**From:**  
**Sent:** Tuesday, June 27, 2023 5:28 PM  
**To:** Callum Harrison  
**Cc:**  
**Subject:** RE: Additional Information - Jones Homes 2023/62/91116/E

Ahead of our meeting on Thursday, Wardell Armstrong, who completed the 'Shallow Mining Investigation Report' (May 2023) have confirmed that the report should respond to the queries raised by the Coal Mining Authority and those raised within the Environmental Health comments. They have also provided a response to query 5 of the Environmental Health comments which is set out below. I have also reattached the comments for reference.

Figure 1: Aerial image showing exploratory hole locations and the extent of the previous investigations at the Site. Blue locations are WA exploratory holes and red locations are third-party exploratory hole locations.<sup>1</sup>

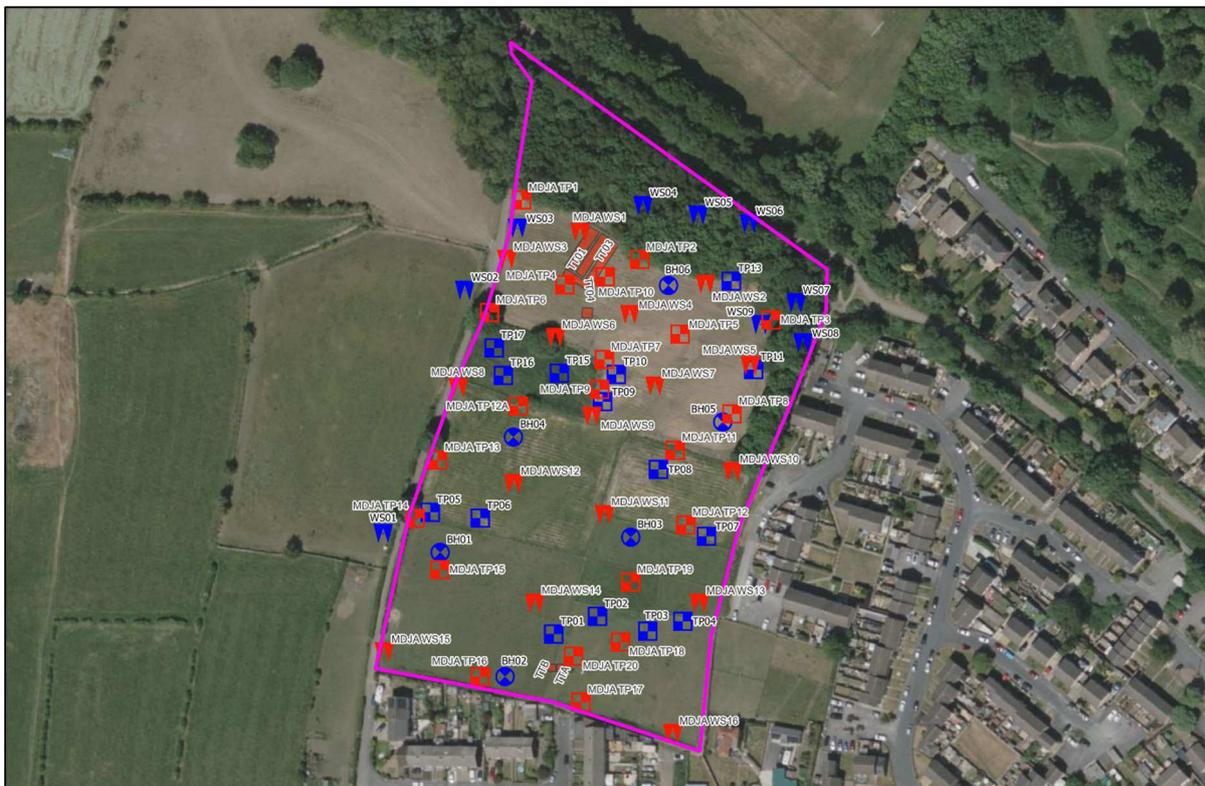
- 5. The ground conditions in the woodland area to the north of the site are unknown yet form part of the application site. We also understand that additional deeper investigations are proposed to establish the coal mining legacy. In the absence of full site information, we consider part of the site characterisation incomplete.**

*Wardell Armstrong (WA) undertook additional site investigation works at the site between 6th and 28th March 2023. The primary aim was to assess the shallow coal mining risk at the site with boreholes advanced to a maximum depth of 30m. In addition, targeted exploratory investigations were carried out along with environmental and geotechnical testing to provide specific additional ground information to aid in the design of the proposed development. This included the woodland area to the north of the site.*

*The additional investigations for the woodland area included 5 No. windowless sample boreholes to depths of between 3.00m and 5.45m. Made Ground was identified to depths of between 1.3m and 4.5m and typically comprised colliery spoil underlain by firm to stiff Clay (likely residually weathered bedrock of the Pennine Lower Coal Measures). 3 No. samples were obtained and tested for a suite of potential contaminants appropriate to the sites former use. A single marginal exceedance of beryllium was recorded at WS05 at a depth of 0.80m but no other exceedances of the residential with plant uptake screening criteria were identified.*

*Further details are included within the WA Shallow Coal Mining Investigation Report dated May 2023. An exploratory hole plan and logs for the exploratory hole positions outlined above are attached.*
